## **City of Ryde Submission**

**Ryde Hospital Stage 2 - SSD-58210458  
1 Denistone Road Eastwood**

**Ryde Hospital Redevelopment**

**Submission Date: 13 December 2023  
COR2023/89/1**

Figure 28 Comparison of the proposed development and approved maximum building envelopes

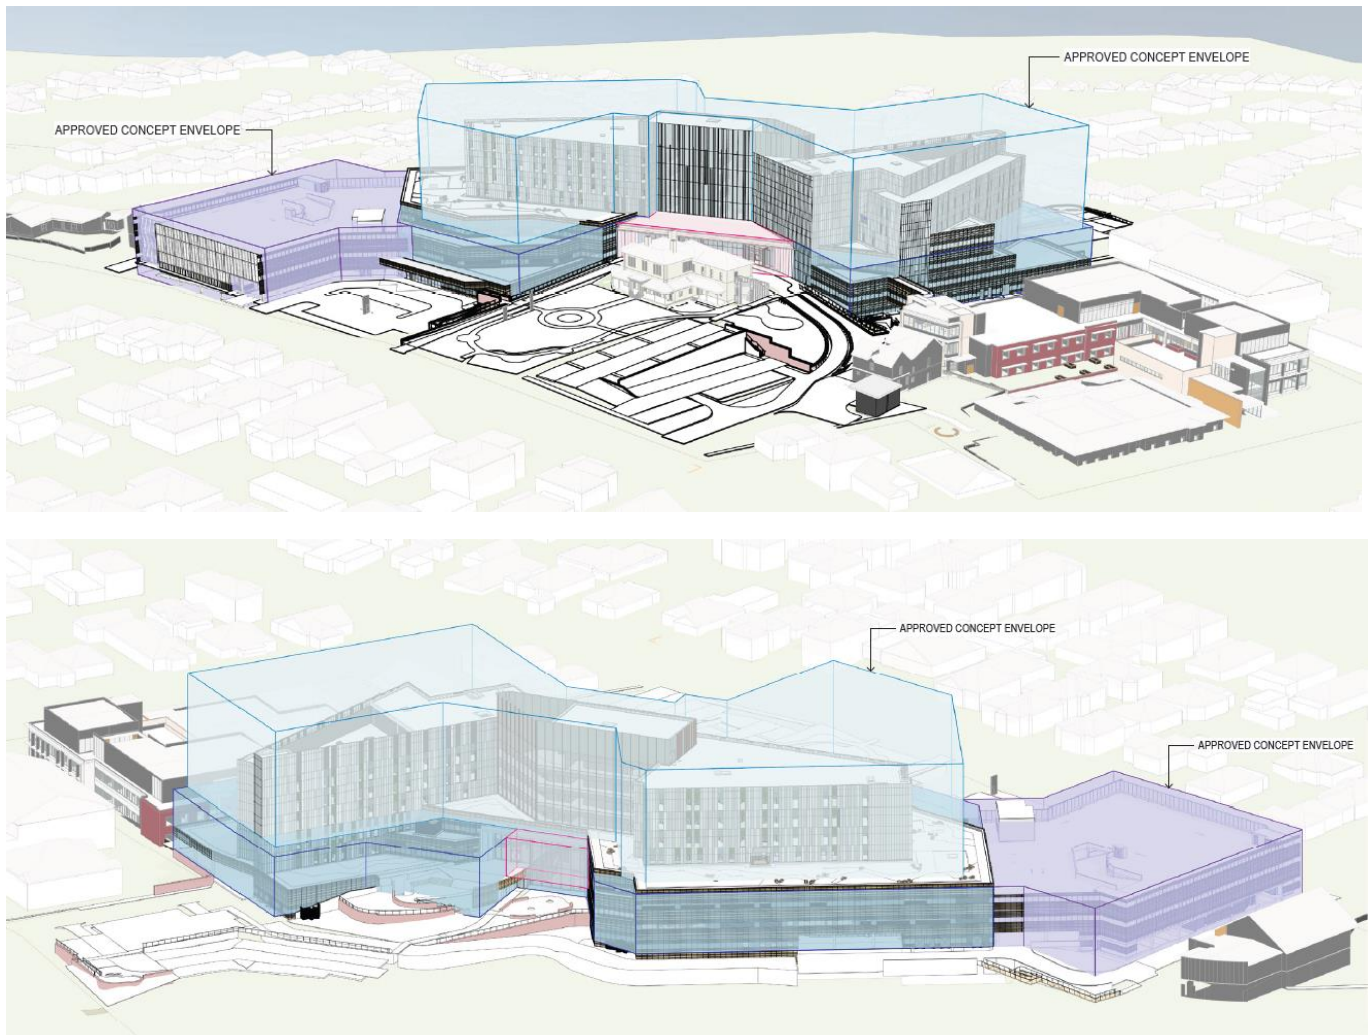
It seems that the new building is not in line with building envelope as approved in the Concept Approval. Page 57 of the EIS states that the podium will exceed the envelope near Denistone House and refers to it as a minor protrusion. However, no details have been provided to demonstrate the extent of this breach and how it may impact on the Denistone House. Details provided in Figure 28 (refer to Figure 1 below) in the EIS does not show any details of height protrusion.

The EIA claims the need is for raised structural slab have resulted in the exceeded height of the podium near the Denistone House. There is no evaluation as to why there is no greater impact on heritage building resulting from changed building envelope. In addition, there is no details of heritage consultants input to the design change.

- Details of the protrusion beyond the building envelope to be provided and evaluated by the heritage consultant and addressed in HIS.
  - Provide clear labels and dimensions on the plans and demonstrate the extent of protrusion and impact emanating from that.
- b. **Condition C6 – Landscaping.** This condition requires all future development application(s) to include a landscape report and plans, prepared by a suitably qualified professional, including the detailed design and treatment of all ground and above ground surface areas on the site and within the adjoining public domain. The landscape plans must be designed having regard to the relevant matters outlined in conditions C3, C4 and C5 of Schedule 2. In this regard the following issues are highlighted:
